**Full Planning Application - 148-154 High Street, Uxbridge (ref. 78696/APP/2024/867)
Landscape Response**

I write on behalf of our client, DNA Uxbridge Ltd, to provide a response to the various landscape comments provided in the recent LBH Urban Design and Landscape response dated 5th March 2025. Oobe have prepared revised landscape drawings, which are listed below, to provide further information / clarification on the points raised.

- Hard Landscape Material Palette (ref. 5903-OOB-XX-XX-RP-L-5005_P01);
- Site Plan (ref. 5903- OOB- ZZ- 00- D- L- 000001 Rev P07);
- Planting Strategy (ref. 5903- OOB- ZZ- 00- D- L- 000040 Rev P04); and
- Urban Greening Factor (ref. 5903- OOB- ZZ- 00- D- L- 000071 Rev P05).

Title Site Plan

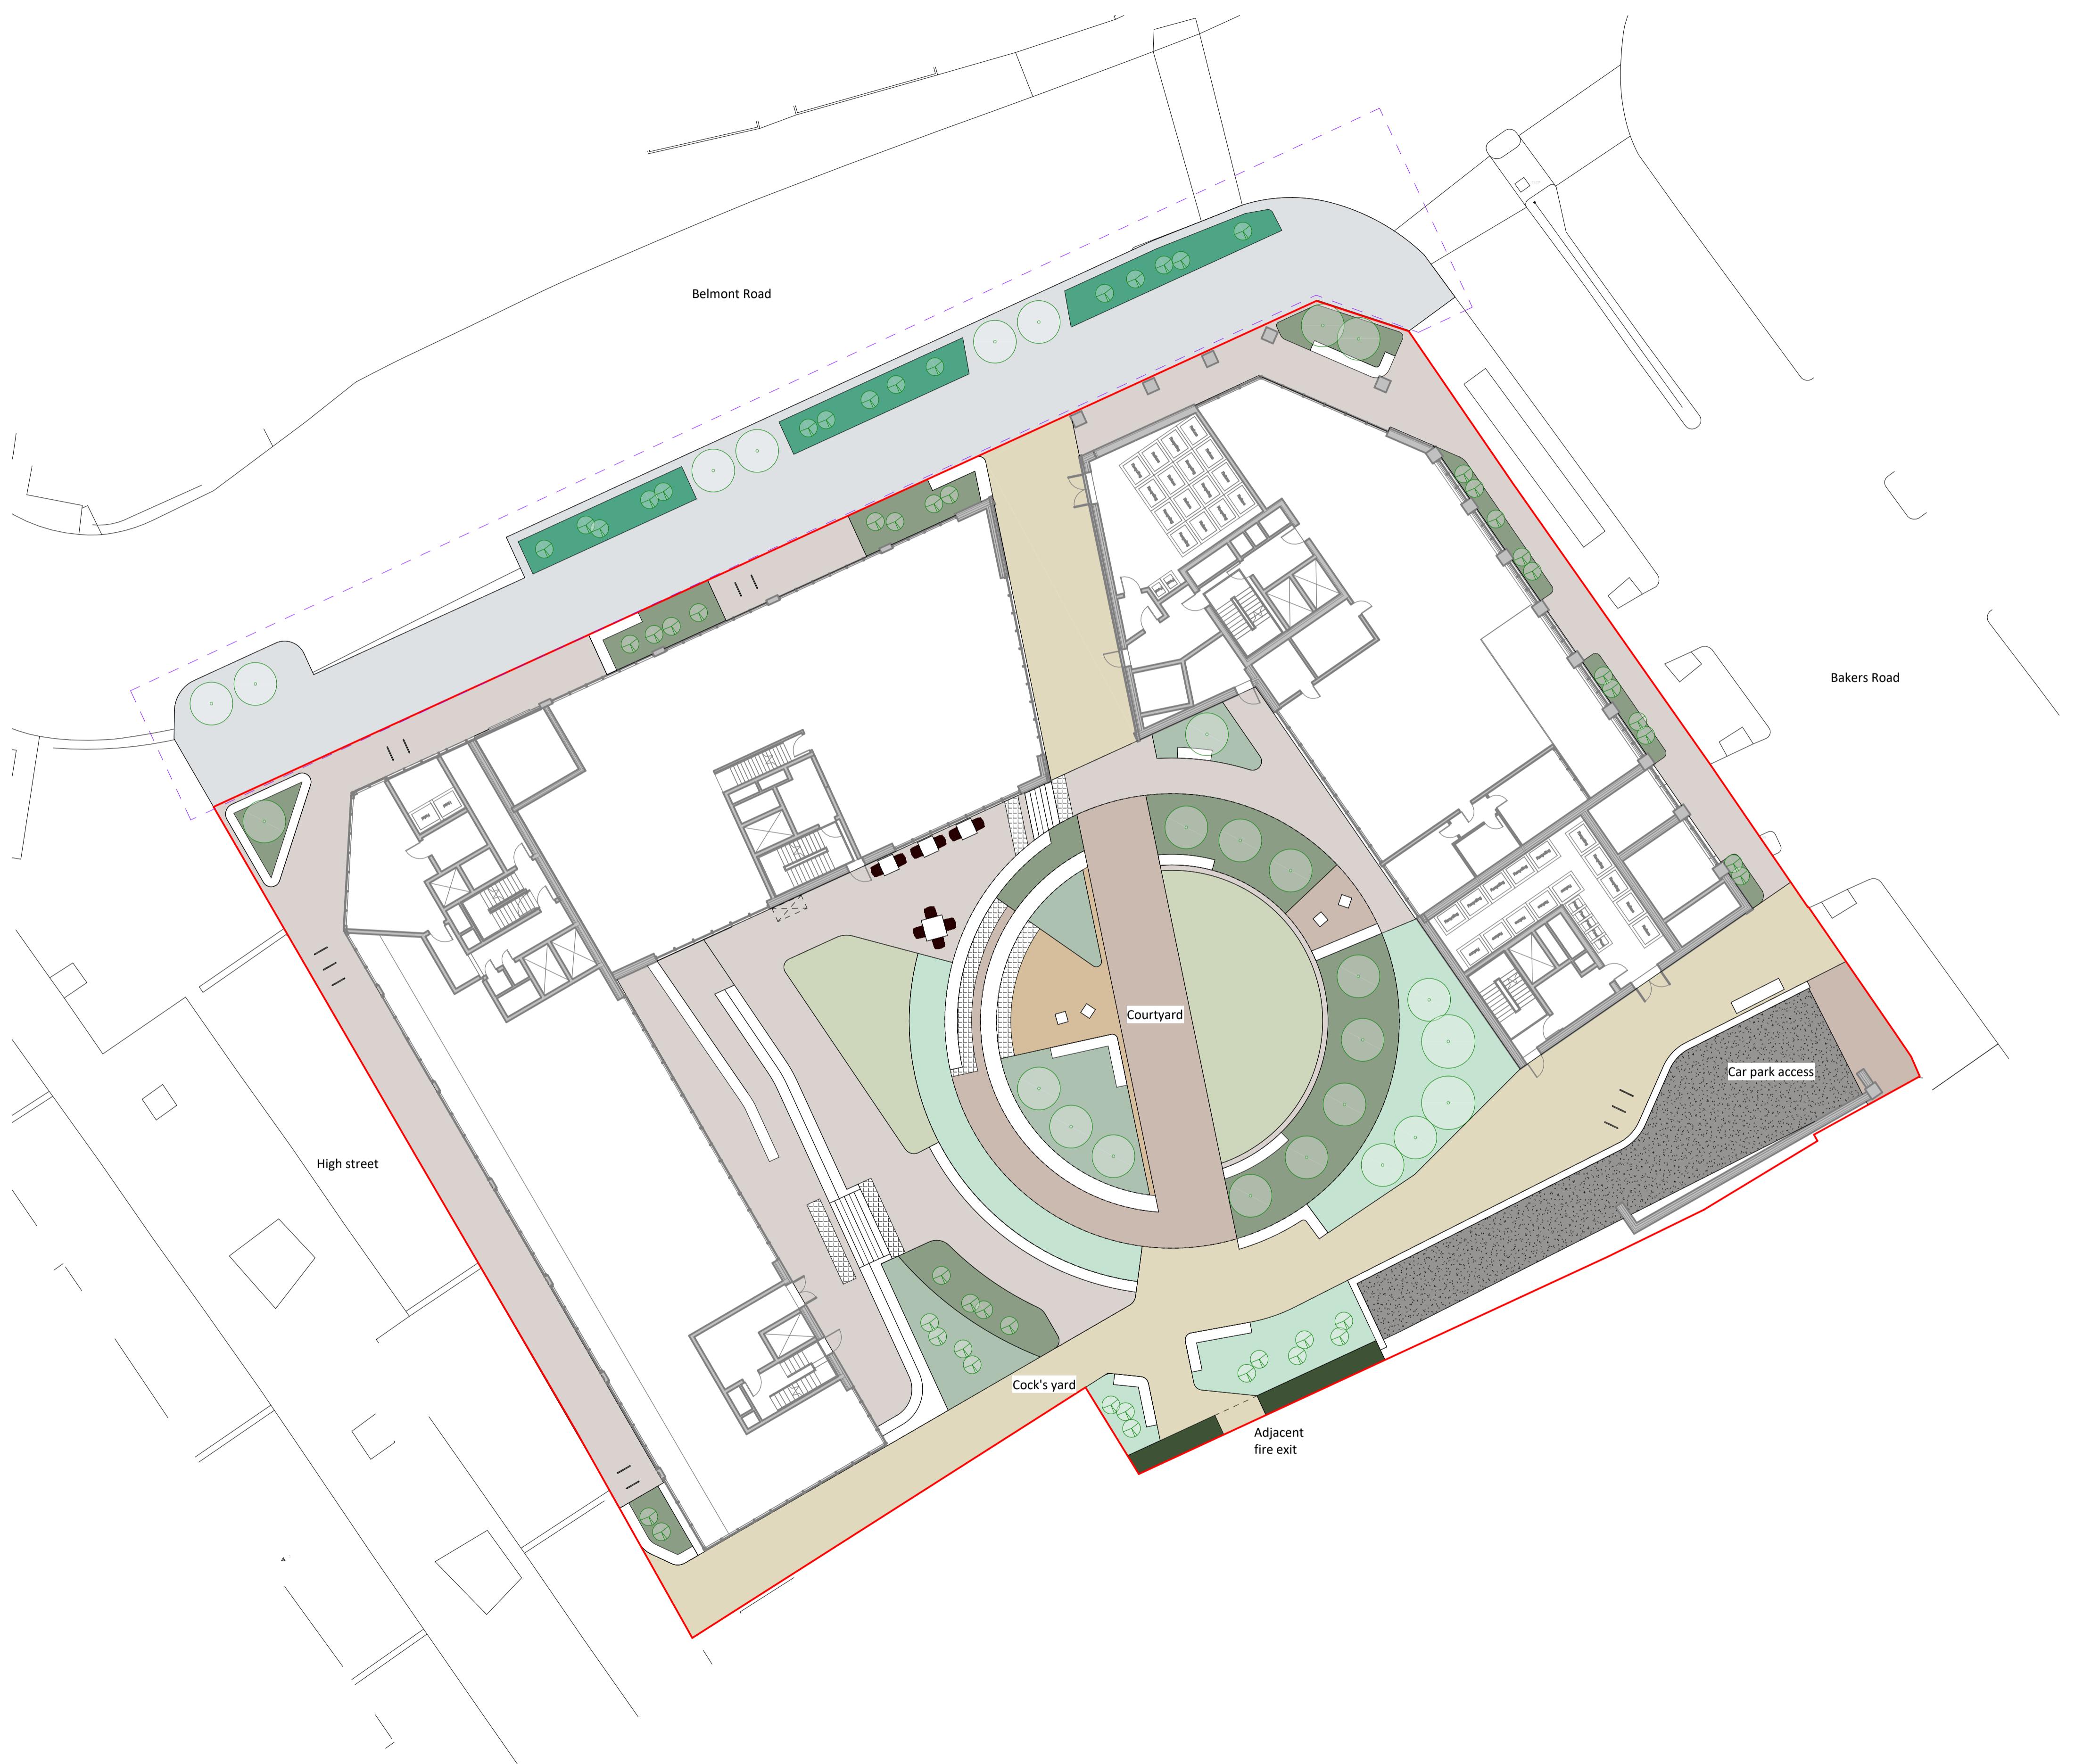
Streetscape along Belmont Road and Bakers Road	<p>The proposed site plan (ref. 5903- OOB- ZZ- 00- D- L- 000001 Rev P07) shows the indicative location of street trees that could be provided along Uxbridge High Street and Belmont Road. Those proposed on the High Street are indicatively shown as Liriodendron tulipifera trees to integrate with the existing trees. Whitebeam have been indicatively proposed along Belmont Road, these are typically smaller, native and hardy within an urban setting. All trees would need to be in underground interconnected tree pit cells and positions are subject to existing services underground, particularly along Belmont Road. No street trees have been proposed along Bakers Road to avoid causing conflict with the bus stops and infrastructure.</p>
Roof terrace landscape	<p>The Landscape Officer requested further clarification regarding the roof terrace landscape. With regard to the planting, the perennial mix provides a range of species with seasonal interest and structure included grasses and flowering species. Species will only be cut in Spring which will provide over winter interest in seed heads etc. In addition, there are many shrubs included which will provide further structure and interest.</p> <p>In addition, to clarify the other requested points:</p> <ul style="list-style-type: none"> • The proposed lawn is proposed as real lawn; • The parapet is drawn at 1100mm in line with Building Regulations, and there are planters located in front of the edge, which limits access to the edge; • With reference to the planter edges materials, steel powder coated planters are proposed, as per ground level proposals. These range from 450-600mm high to provide a sense of enclosure, protection from wind and offer definition to the primary useable space away from the parapet edge. There are no level changes on the terrace.
